Rosefield Solar Farm (EN010158)

**Buckinghamshire Council's Updated Principal Areas of
Disagreement**

Buckinghamshire Council

June 2026

DOCUMENT:
ENVIRONMENTAL STATEMENT
VOLUME 3: FIGURES
REGULATION 5(2)(a)

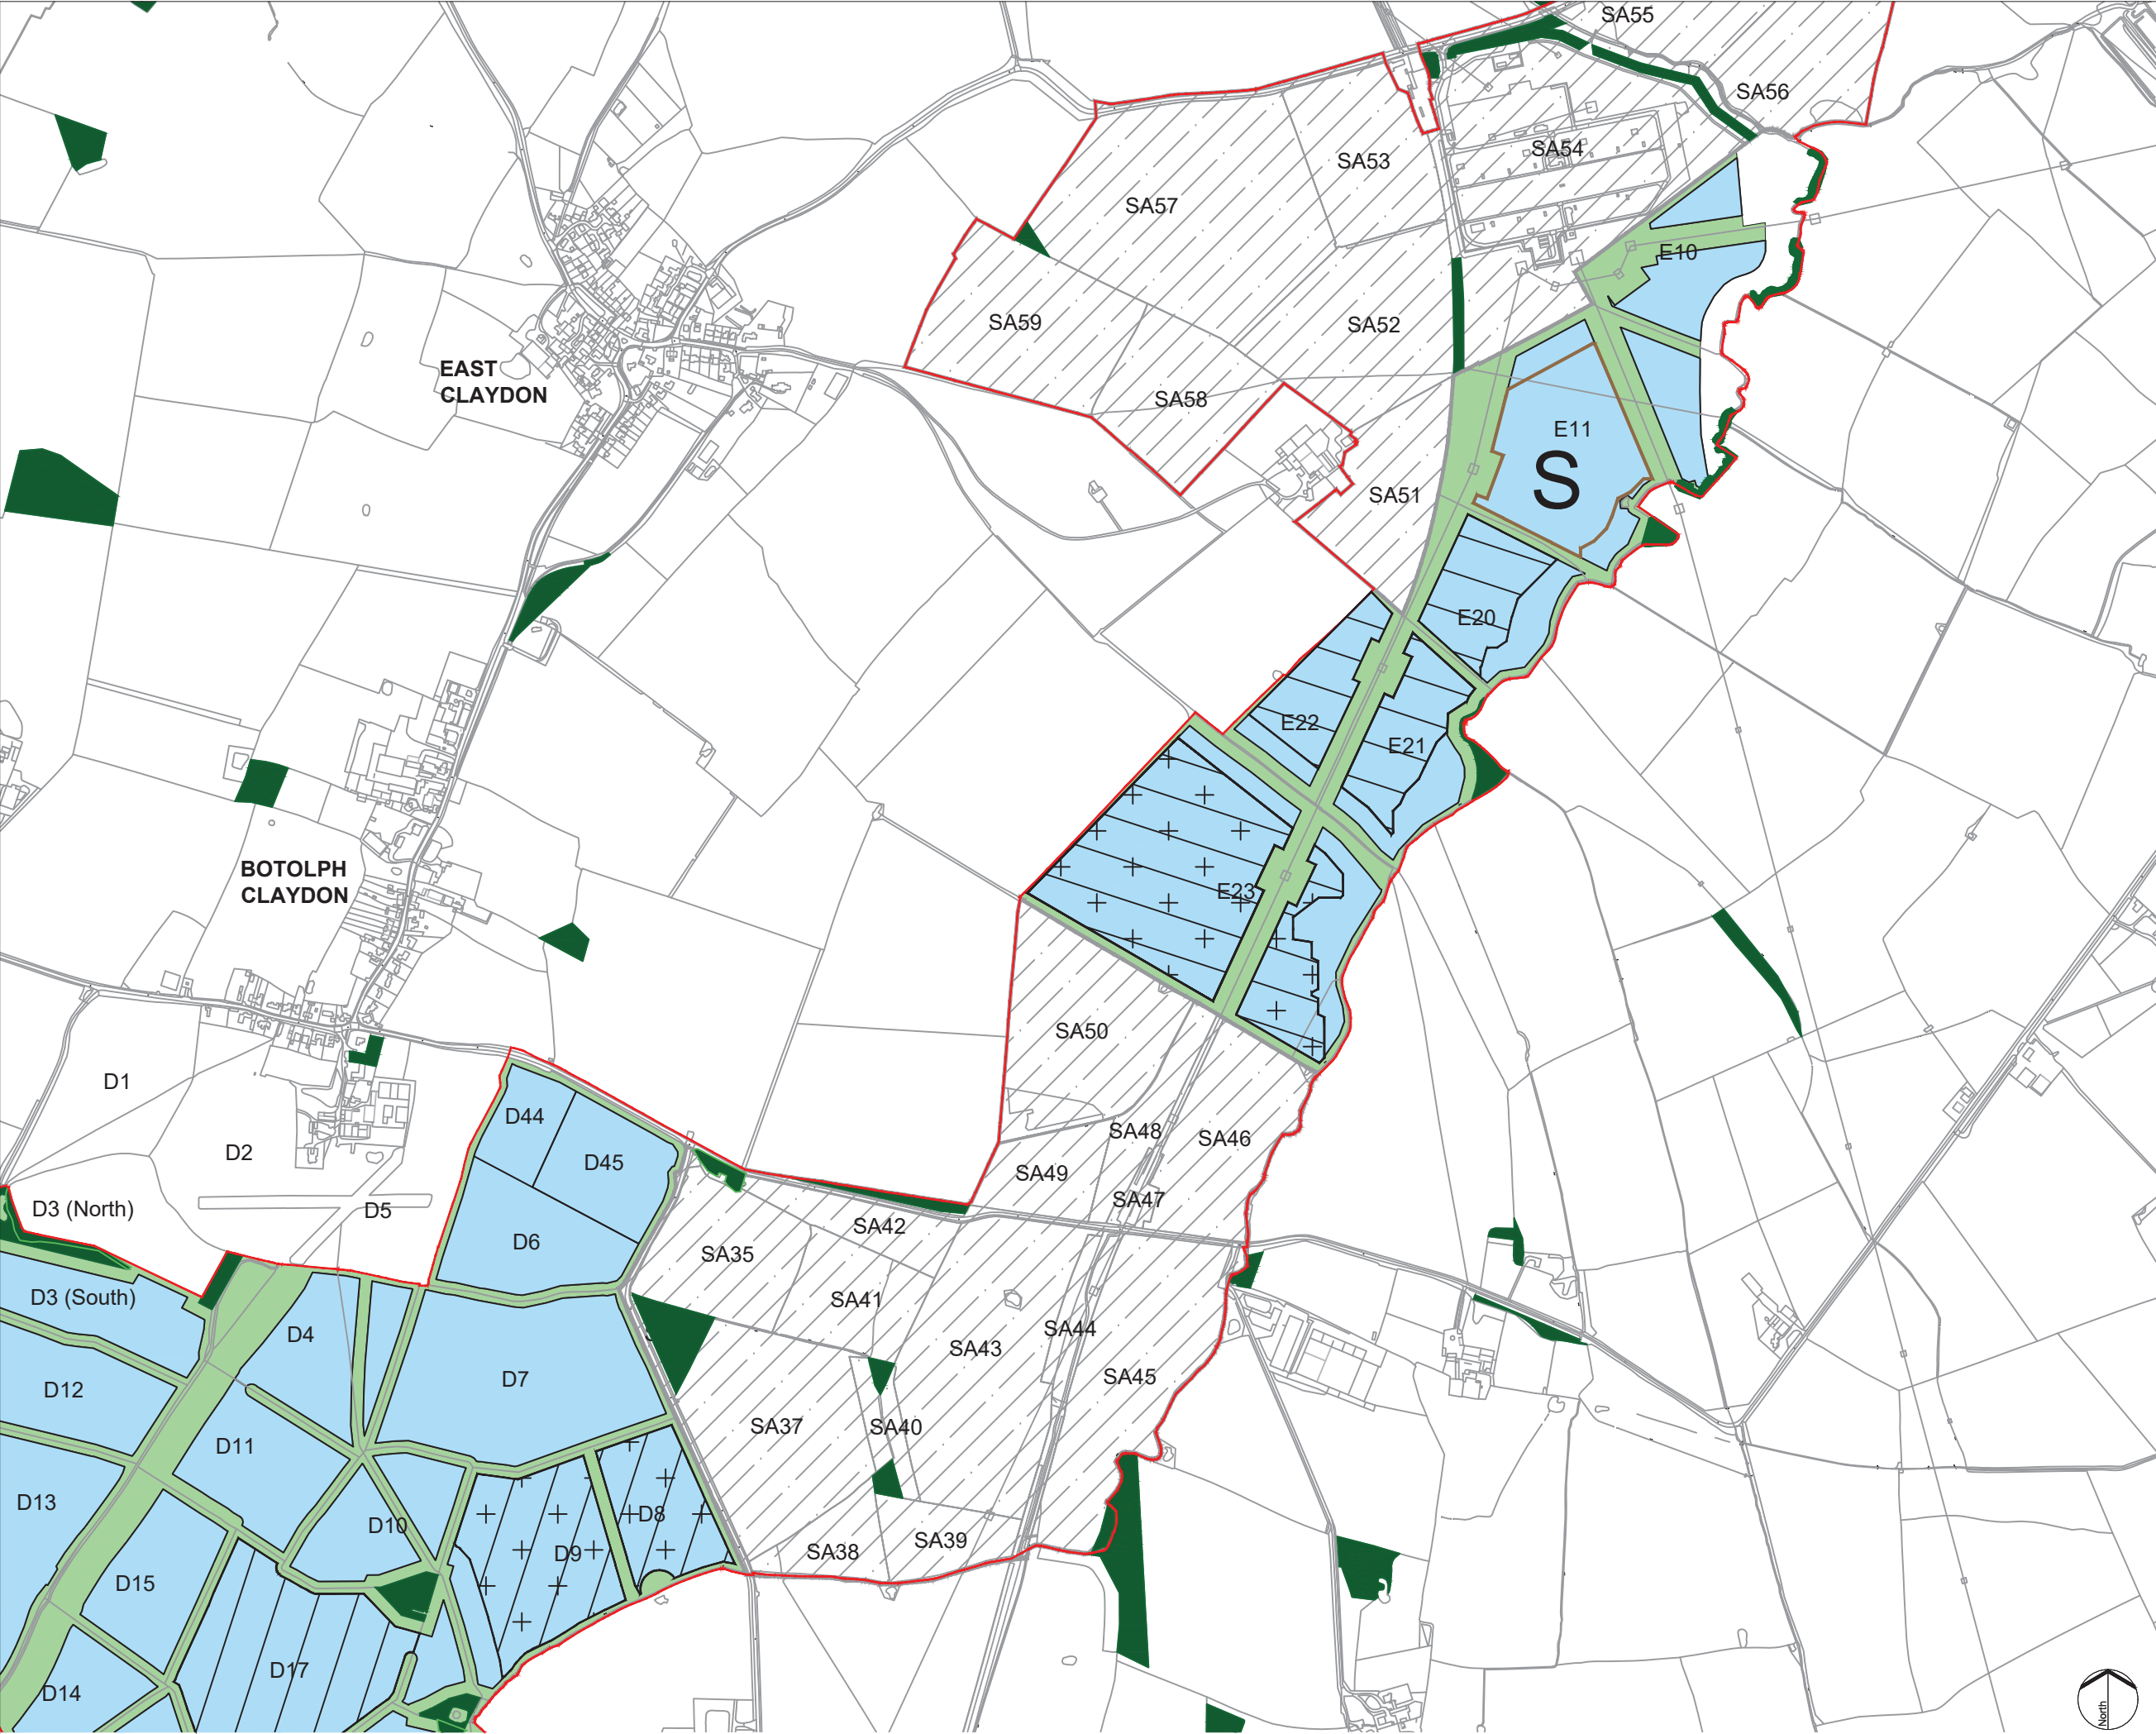
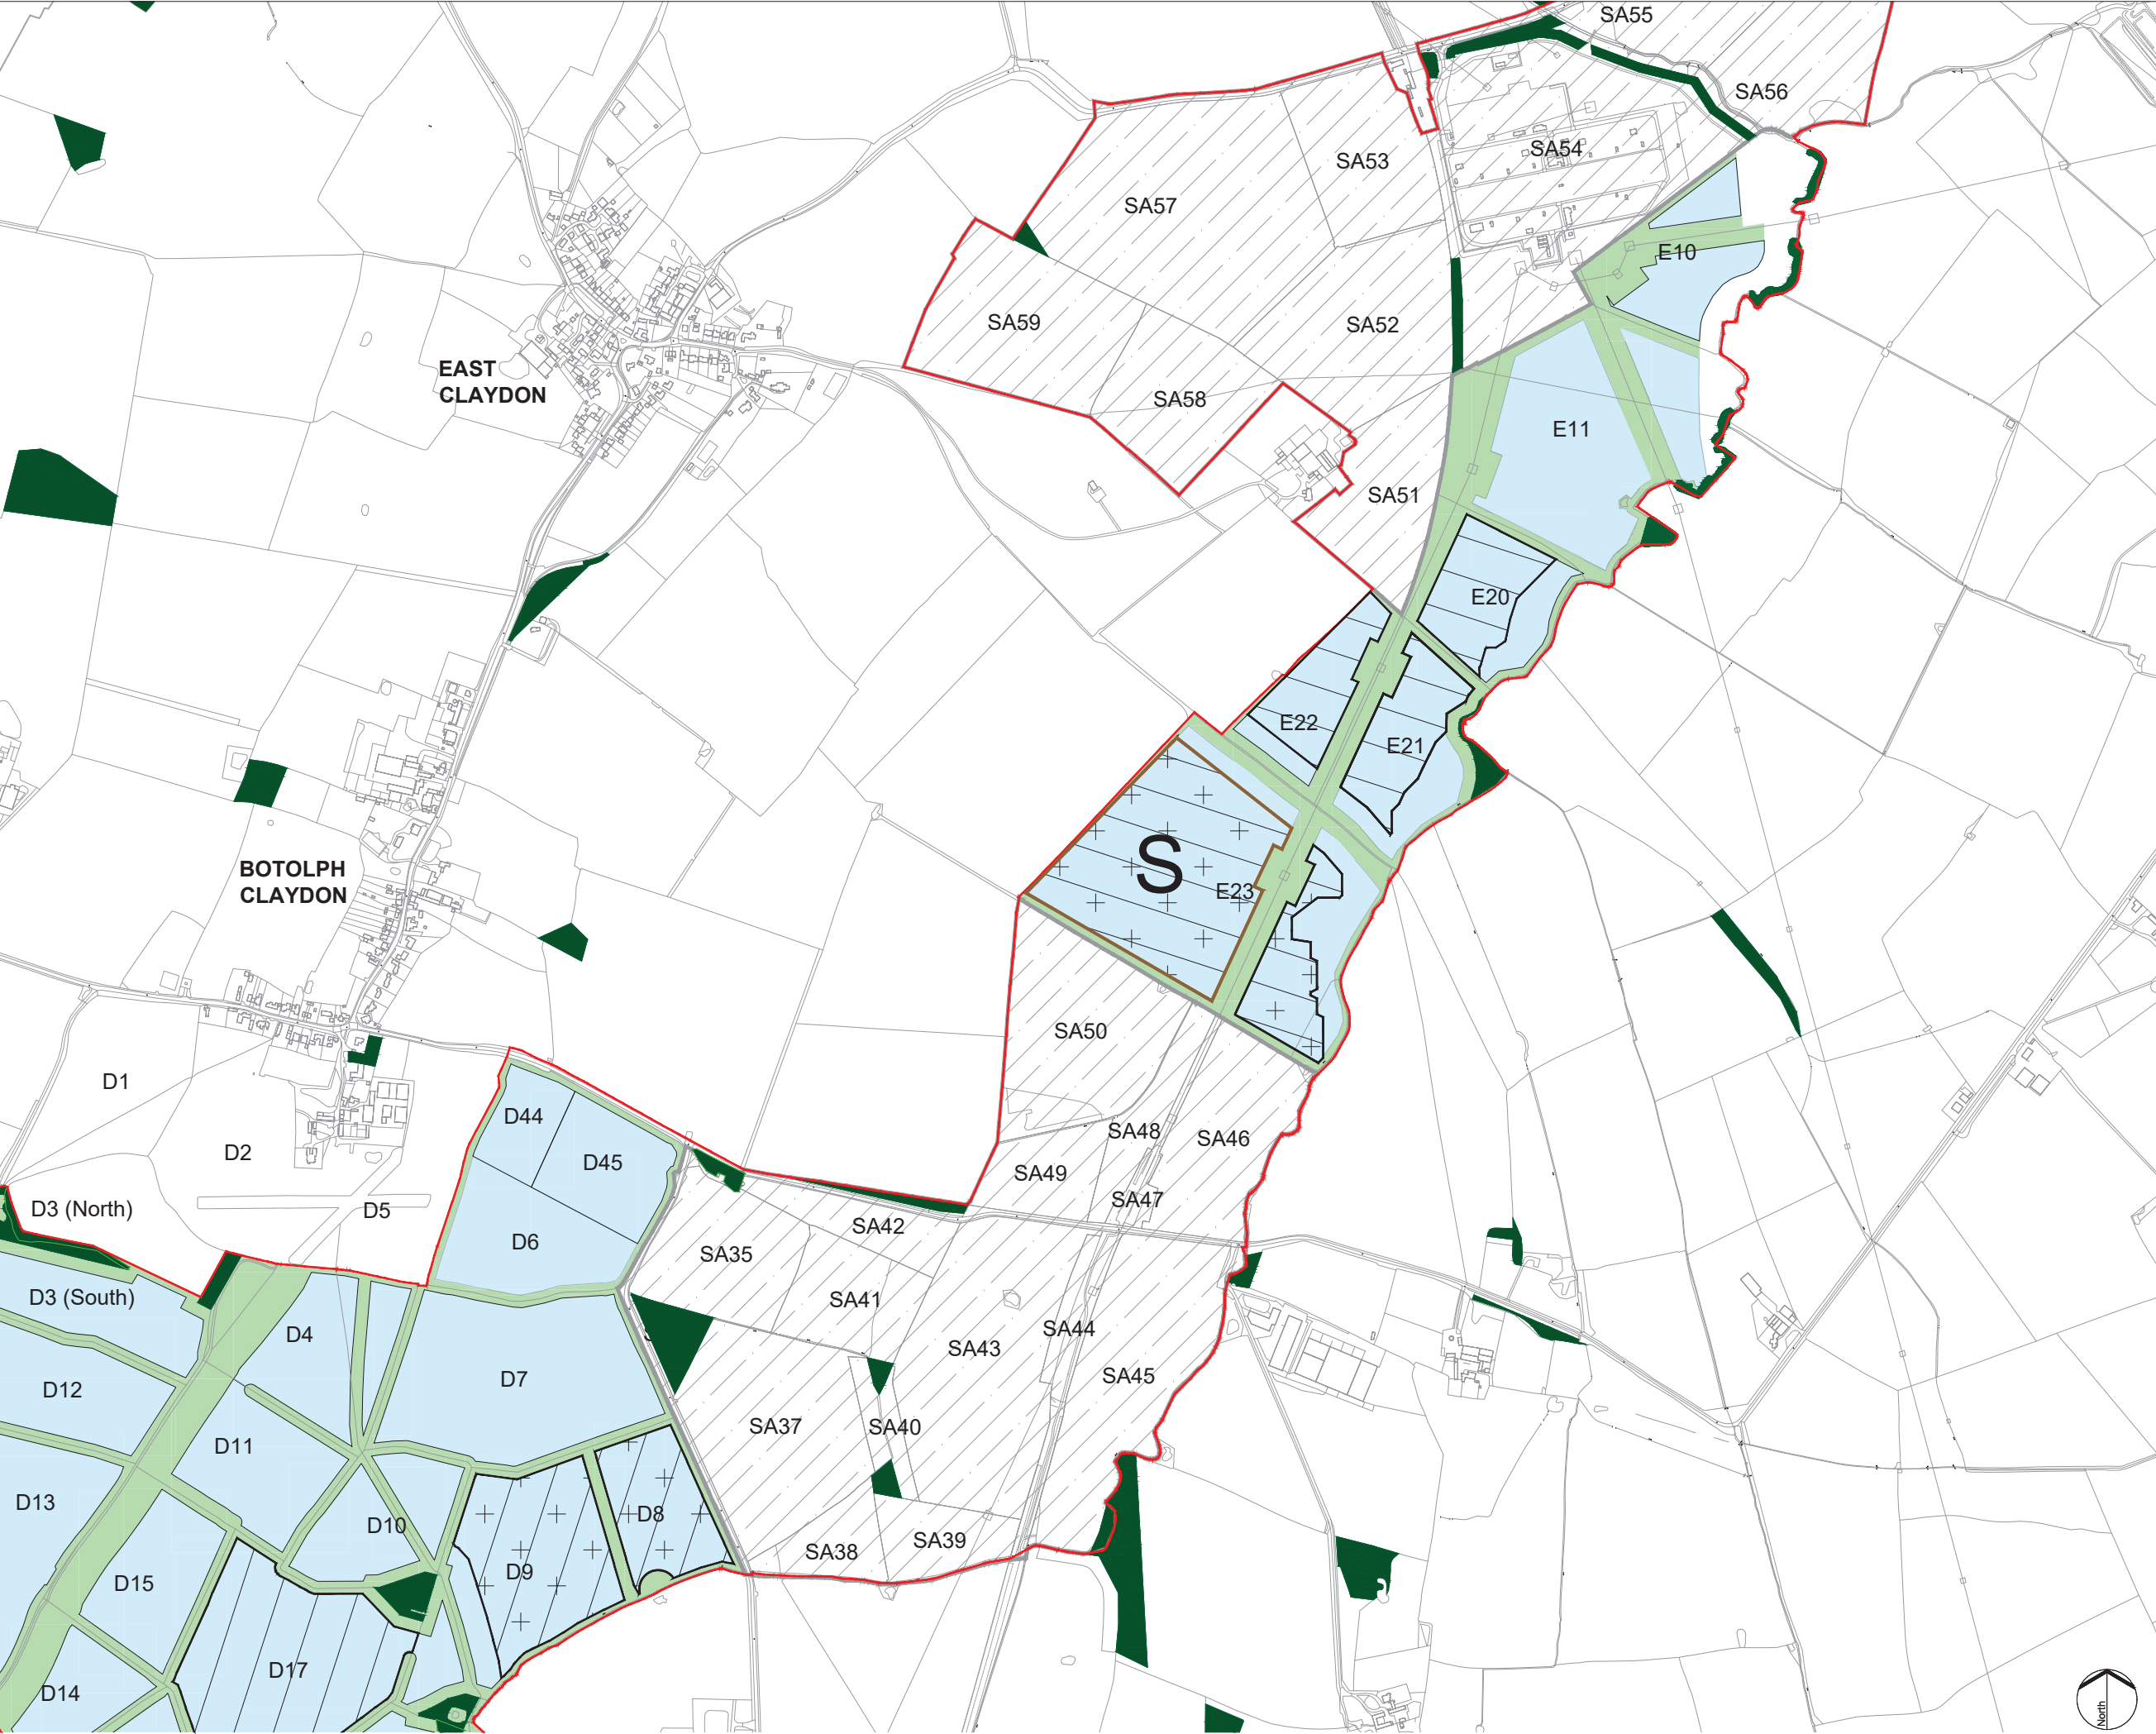
Area of Concern	Explanation	Remedy Measures	Likelihood of Resolution
<p>Site Selection</p>	<p>Site selection process appears to have been driven primarily by single landowner availability, not by a constraints-led or environmentally proportionate assessment.</p> <p>Lack of evidence that other land parcels within the 10km search area were identified, evaluated or discounted on environmental, landscape or planning grounds.</p> <p>No clear demonstration that the Applicant considered alternative locations for the BESS, including less visually sensitive parcels.</p> <p>Insufficient assessment of the undulating landform, which intensifies visual prominence from PRowS and settlements.</p> <p>Failure to consider whether flatter or more enclosed areas both within and outside the landholding could reduce landscape, heritage or ecological harm.</p> <p>Incomplete exploration of opportunities to co-locate the BESS with existing or consented energy infrastructure, including the</p>	<p>Provide an alternatives assessment, demonstrating a constraints-led approach to site selection across the full 10km search area.</p> <p>Reassess all available land parcels (inside and outside the willing landowner area) against ecological, landscape, heritage and PRowS sensitivity.</p> <p>Relocate the BESS away from fields D8/D9 to a less visually elevated and less heritage-sensitive parcel with better containment.</p> <p>Demonstrate that the chosen layout represents the least-harm option within the Order Limits, evidenced through sequential design testing.</p> <p>Provide an options appraisal for co-location with existing or consented infrastructure, especially the National Grid substation and adjacent consented BESS.</p> <p>Include detailed topographical and ZTV-led analysis showing how alternative siting could reduce visual harm.</p>	<p>Low</p>

Area of Concern	Explanation	Remedy Measures	Likelihood of Resolution
	<p>National Grid substation and consented BESS sites.</p> <p>Insufficient justification for selecting fields D8/D9 for the BESS despite elevated, visually exposed, and heritage-sensitive context.</p> <p>No transparent assessment showing whether alternative layouts within the Order Limits could avoid highest-sensitivity landscape, ecological and heritage receptors.</p> <p>Issues related to removal of panels from PV for ecological and landscape reasons are addressed in the appropriate section below.</p>	<p>Revisit design to avoid siting infrastructure in parcels within the highest ecological sensitivity, including areas forming critical habitat connectivity.</p> <p>Supply full justification for why alternative land parcels could not be used, aligned with EN-1 and EN-3 requirements for proportional alternatives assessment.</p>
